DRAWN BY: O.E. WATTS	APPROVED BY:	REVISIONS	OLIVER E. WATTS CONSULTING ENGINEER COLORADO SPRINGS	PROJECT 16140 OLD DENVER ROAD PART NW1/4 SEC. 26, T.11S., R.67W, 6TH P.M. EL PASO COUNTY	SHT. NAME CONSTRUCTION DOCUMENT COVER SHEET	SHT. NO. 1 OF 3	
	DATE: 10-23-19	PROJ. NO.						
	DWG. NO.: 17-4958-06	DWG.

PROJECT 16140 OLD DENVER ROAD  
PART NW1/4 SEC. 26, T.11S., R.67W. 6TH P.M.  
EL PASO COUNTY

## GRADING AND EROSION CONTROL PLAN

1/2"=1'-0"

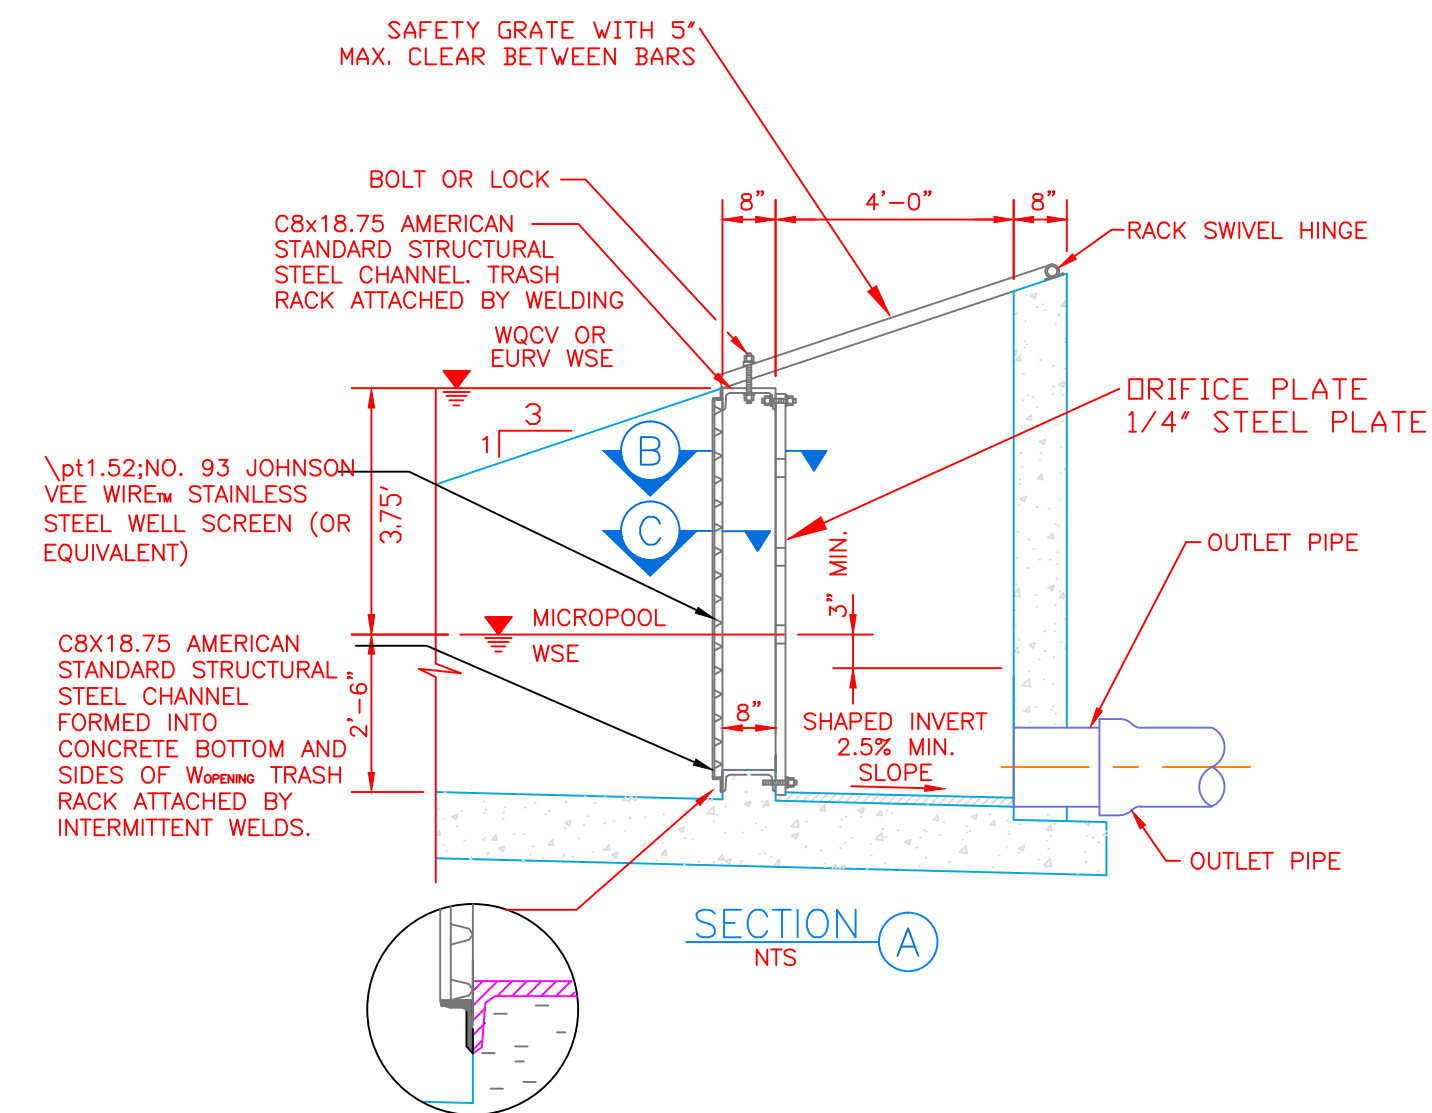
This does not meet the criteria for a full spectrum extended detention basin outlet structure discussed during the October 7, 2019 meeting.

- Unresolved. Extended Detention Basin construction details are missing. During the meeting the expectation was to construct the pond as an extended detention basin.
- The extended detention basin is missing the following components:
- maintenance access ramp
  - forebay
  - trickle channel
  - micropool
  - outlet structure design for FSD
  - spillway cross section
- Below are examples.
